Yapton Parish Council
Mr A Gardiner
38 Ruskin Avenue
North Bersted
Bognor Regis
PO22 7ND

Your Ref: OWPC13289
Our Ref: Y/5/17/OUT
Please ask for:
Mr A Wood

Outline application for 51no. dwellings with all matters reserved except for access. This application is a Departure from the Development Plan.

Cinders Nursery & Land R/O Cinders Lane Yapton

CONCEPTUAL LAYOUT

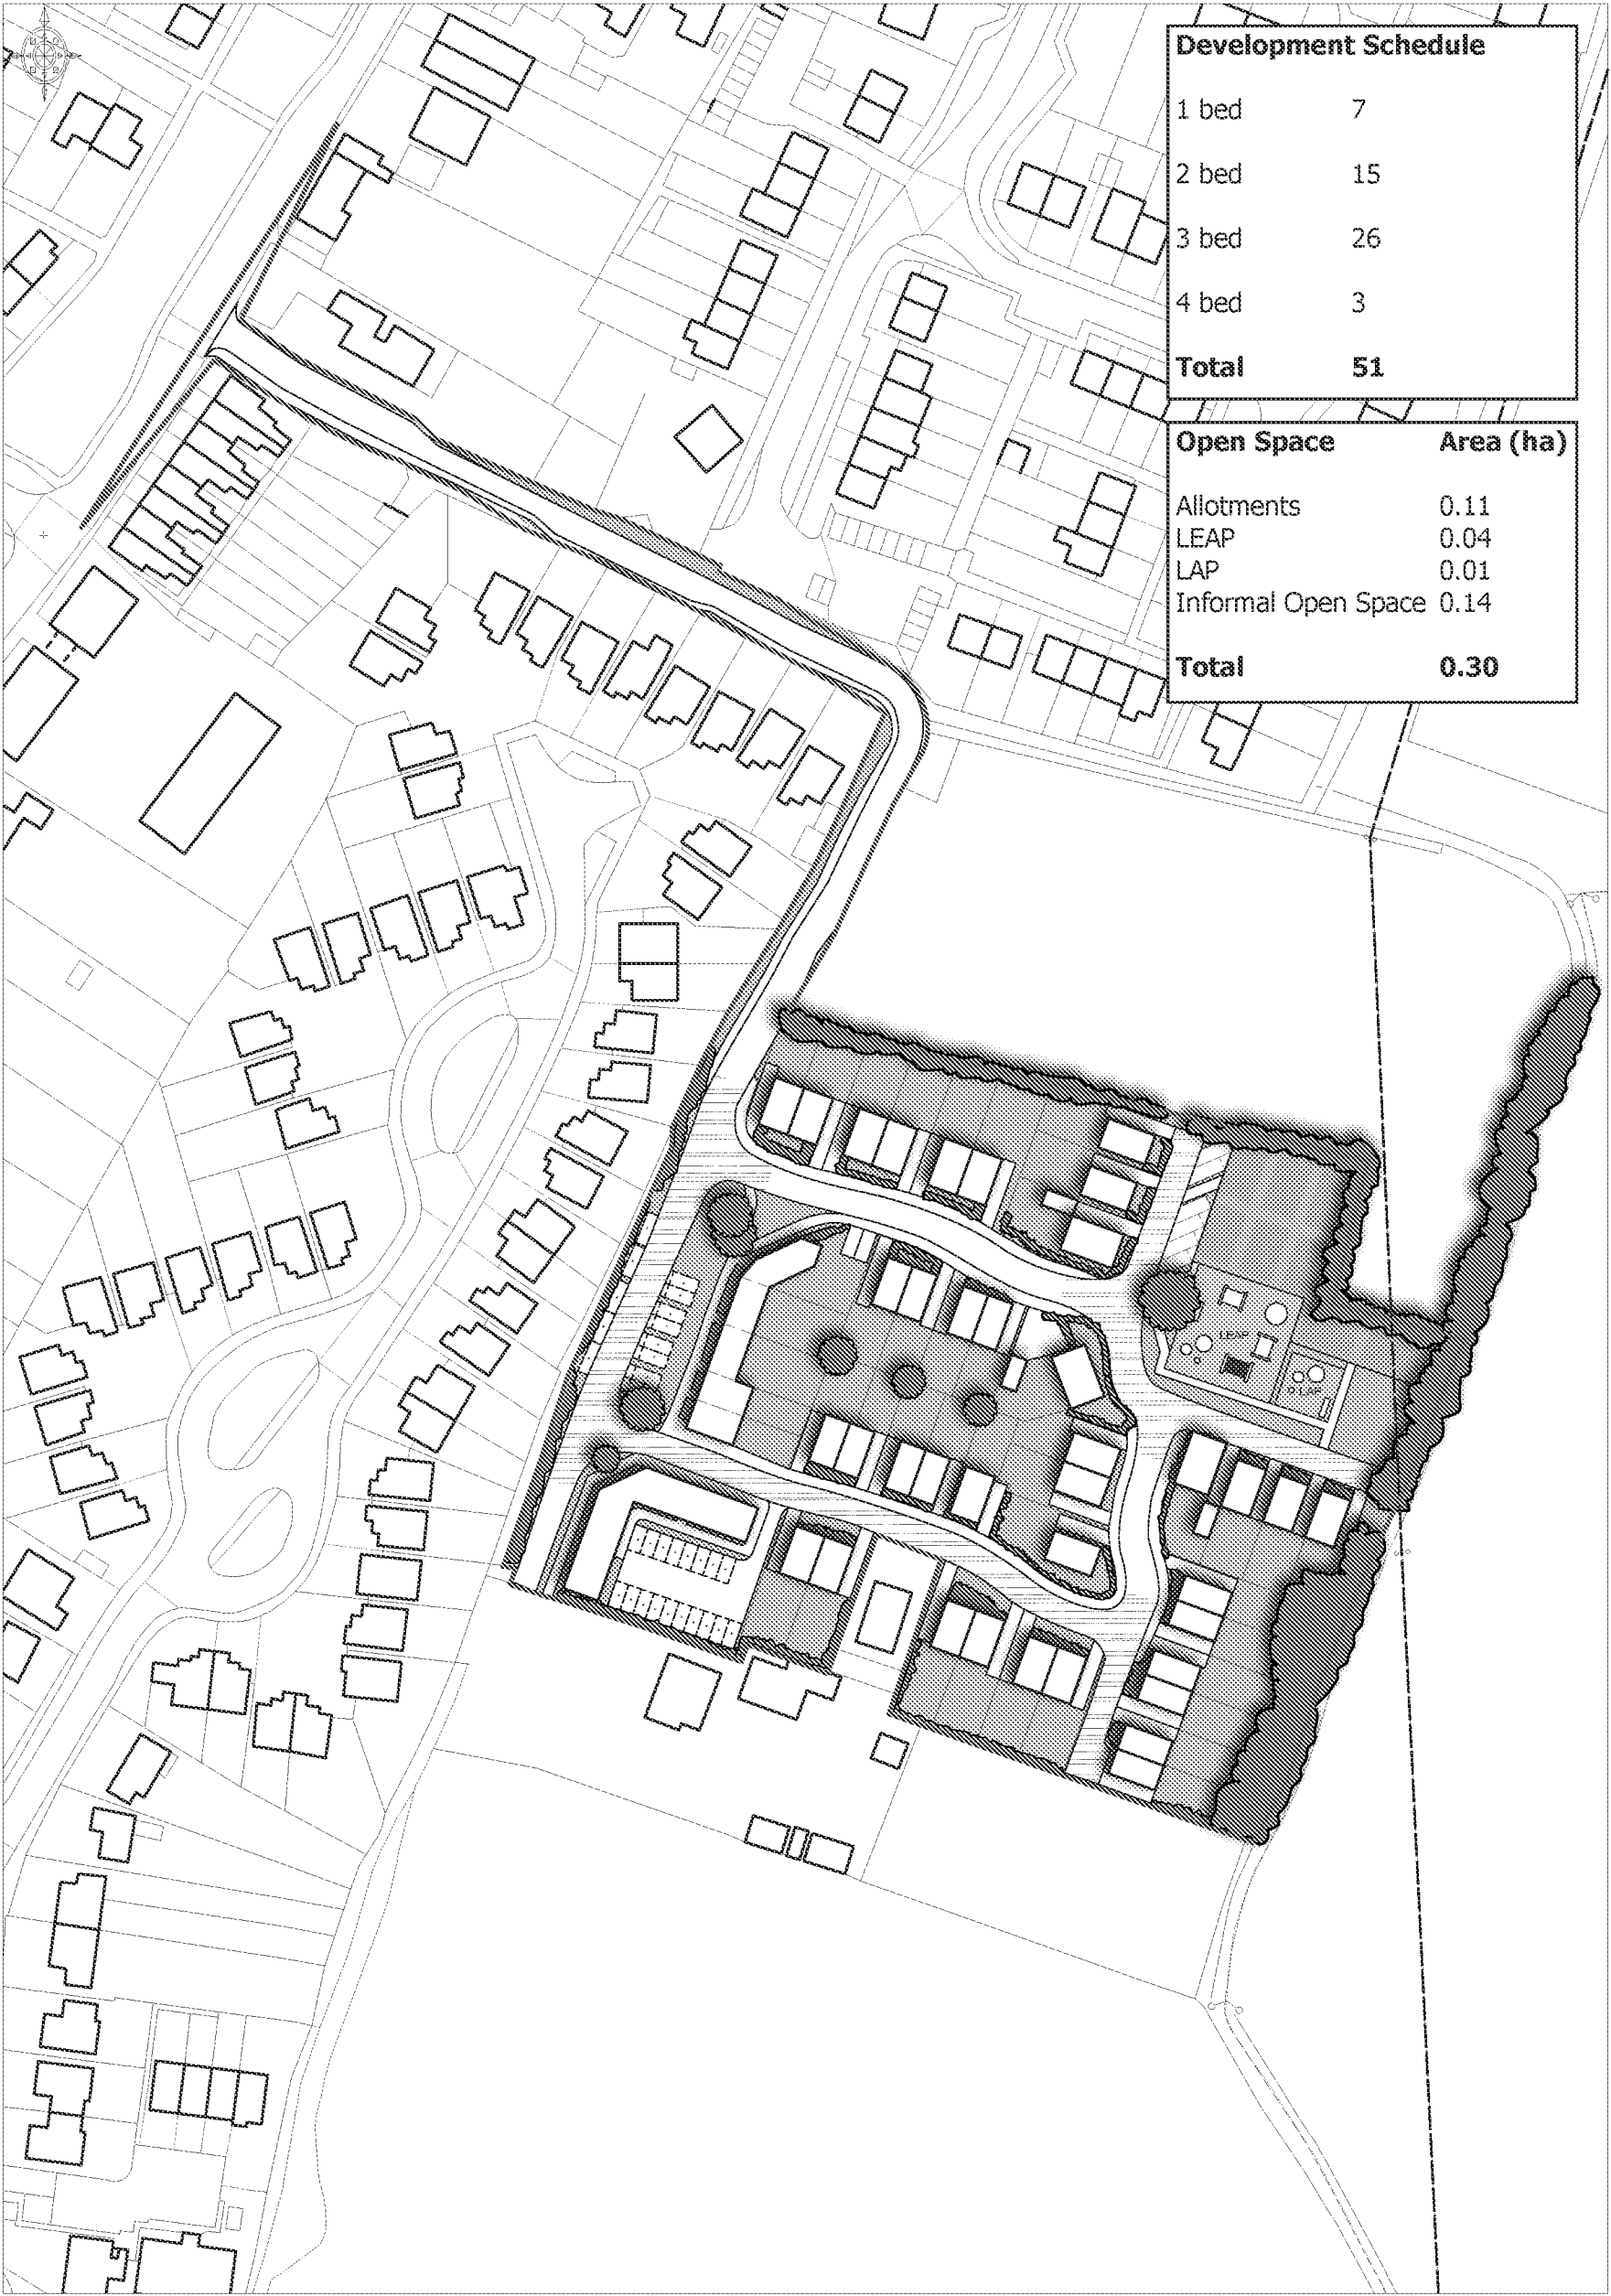
The Parish note that pedestrian links within the site are compromised with pedestrians being encouraged to cross Cinders Lane on a blind bend. We would seek better pedestrian links/walkways within the scheme linking to the existing footpaths to the north of the site, enabling easy access to the allotments and countryside without the need to cross Cinders Lane.

The proposal's outlined open space is not fully dedicated as open space but has a dual use being used in part as car parking. The Parish would seek fully dedicated open space and improved landscaping to reflect the rural nature of the site and its backdrop.

SURGERY ACCESS VISIBILITY SPLAY (SCALE 1:200)

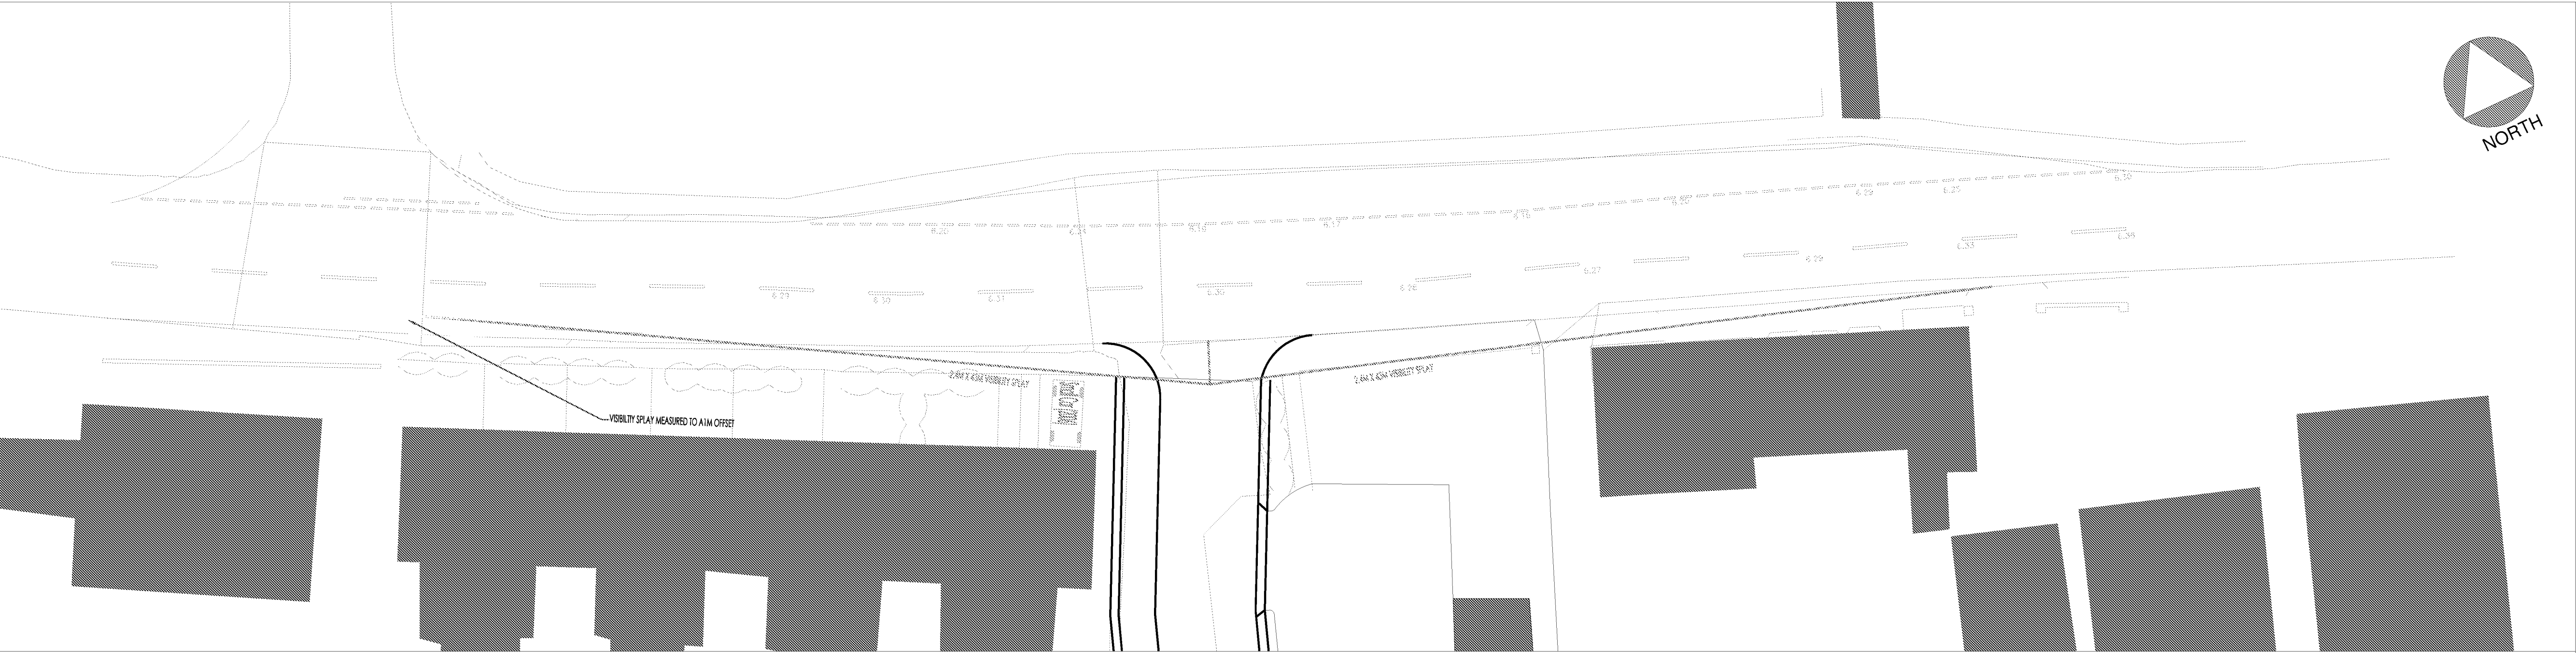
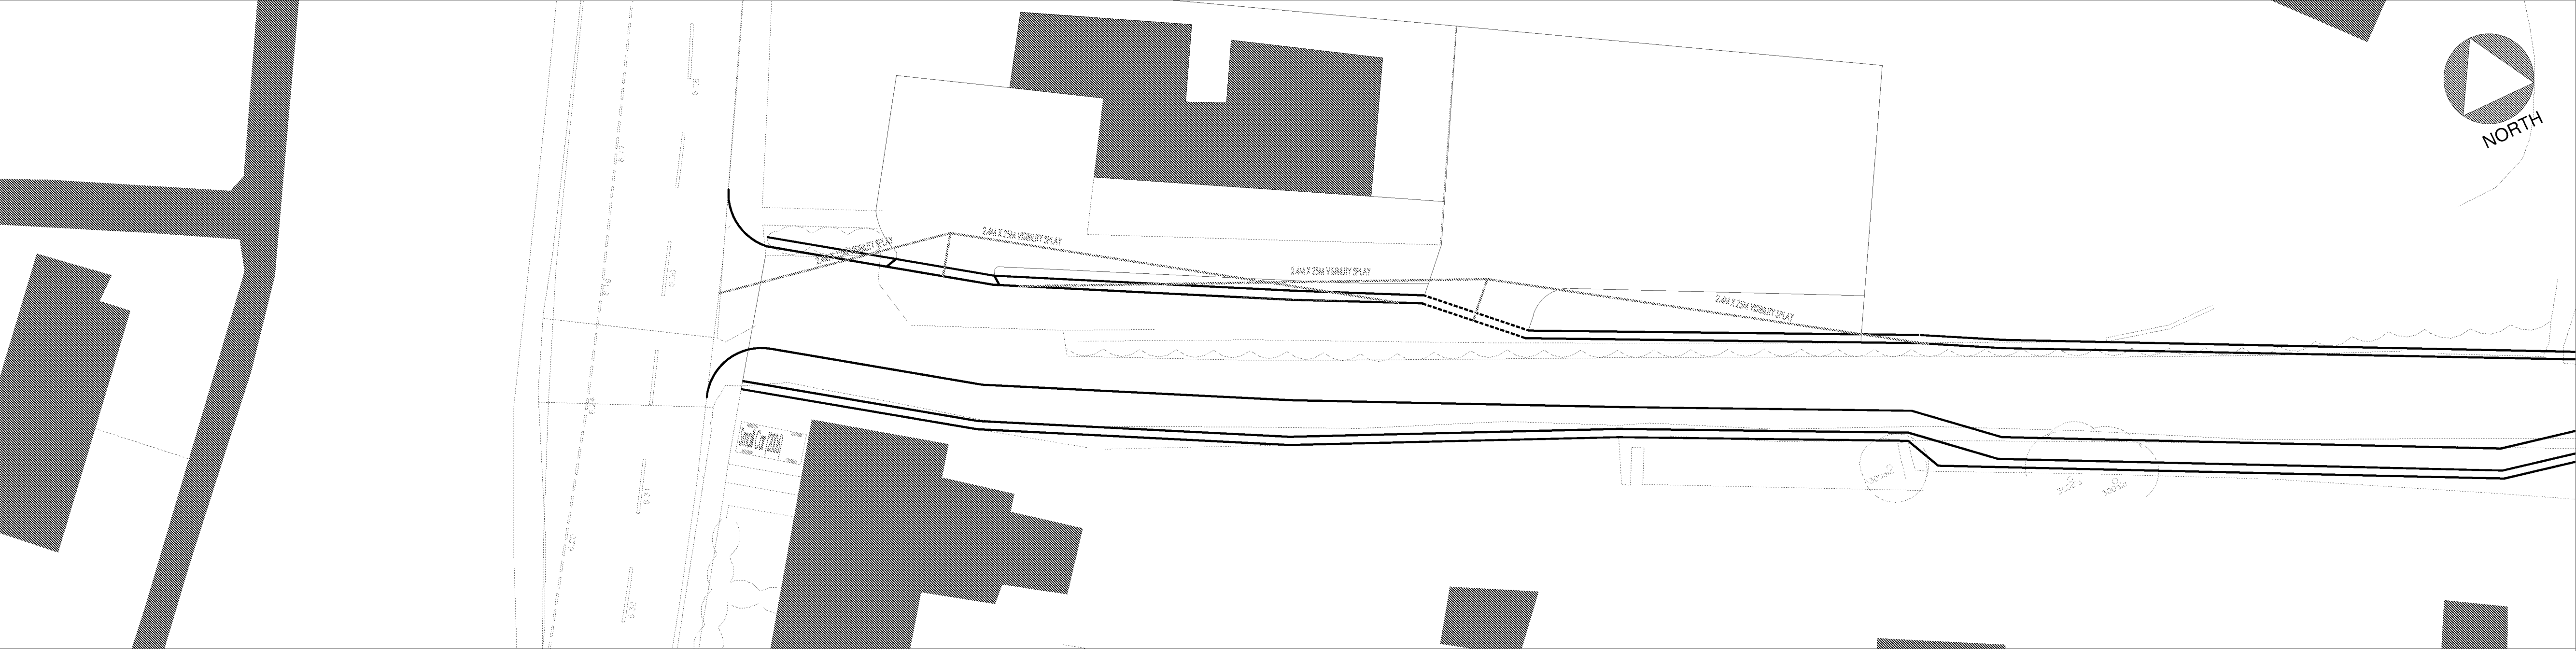
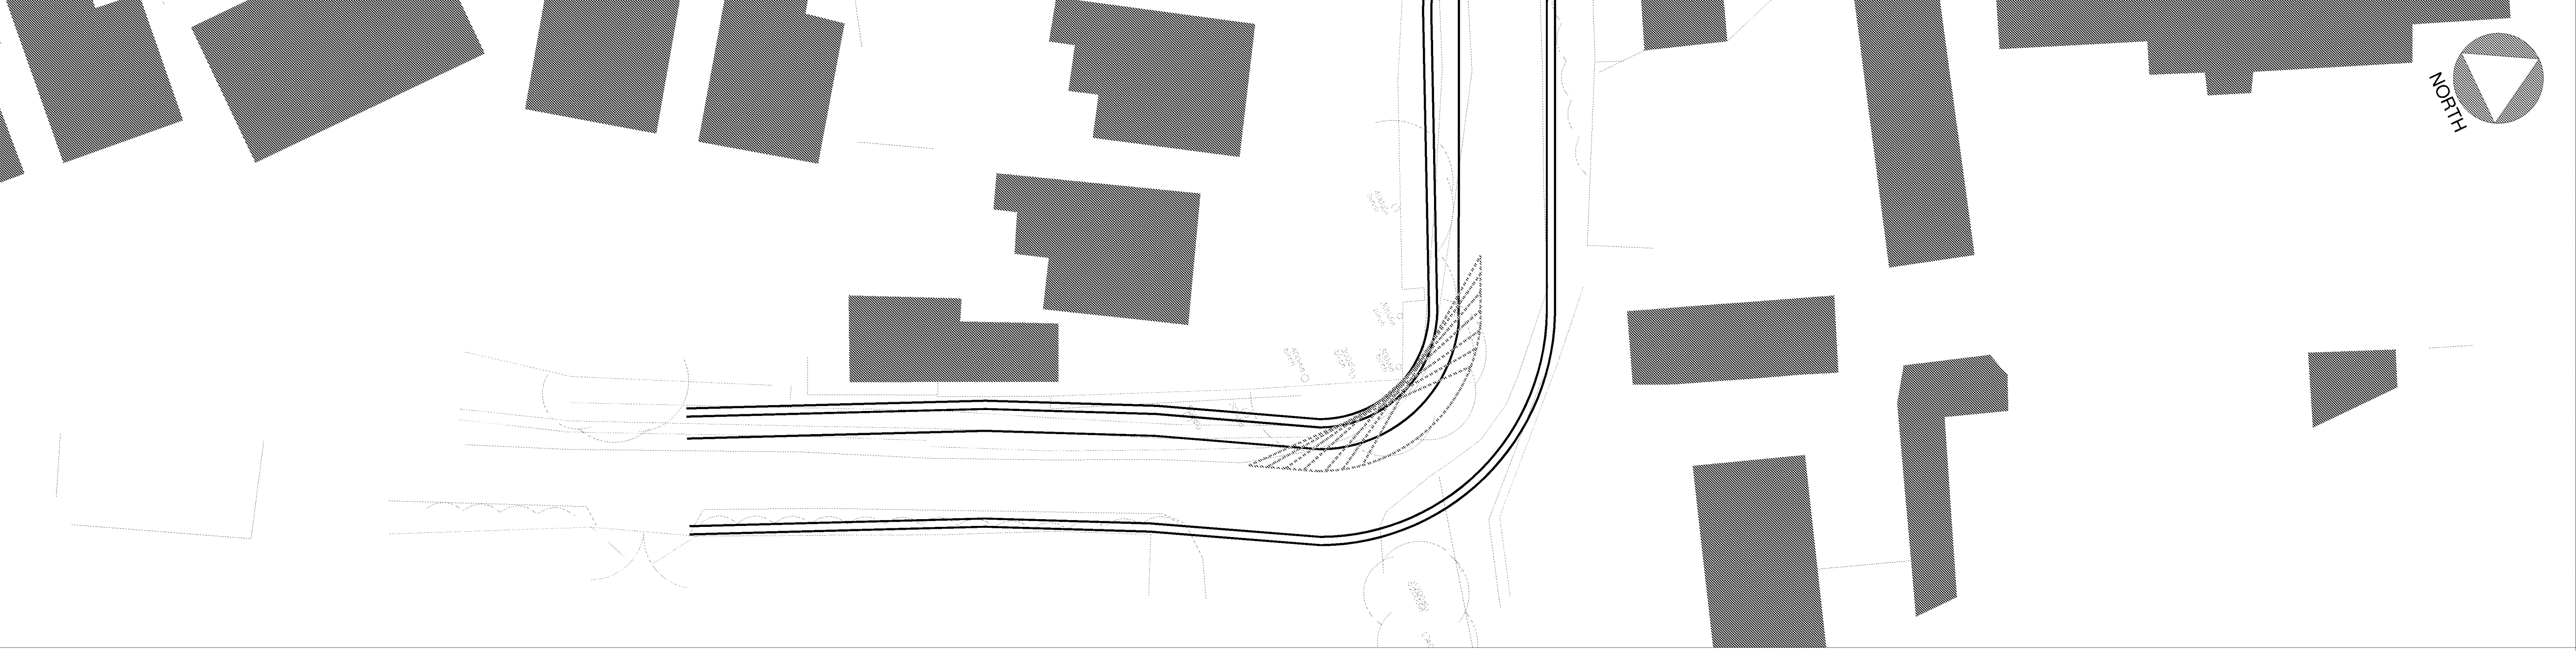
The Parish Council would reiterate its concerns relating to the access arrangement to and within the site area. We would seek further transport studies on the junction of Cinders Lane and Bilsham Road by way of a condition attached to any decision.

The site is accessed via a proposed improved junction with Cinders Lane and Bilsham Road. However, this section of Bilsham Road is both a busy section of road and subject to persistent congestion due to resident street parking and customers parking outside Bilsham Stores. Congestion and conflict is further compounded at this junction by traffic movements to and from Meadowcroft Surgery and the allotments. There is a need to ensure that pedestrian access to Bilsham stores and the surgery remain safe and a more robust solution put forward to ensure a safe junction for cars and pedestrians. The Parish Council would ask that this junction and its proposed site-lines be re-examined along with the surgery parking arrangement.

The Parish would suggest that the surgery has only one access point or a restriction placed on the front car park ensuring that it is used purely for staff lessening the frequency of use of this second access point.
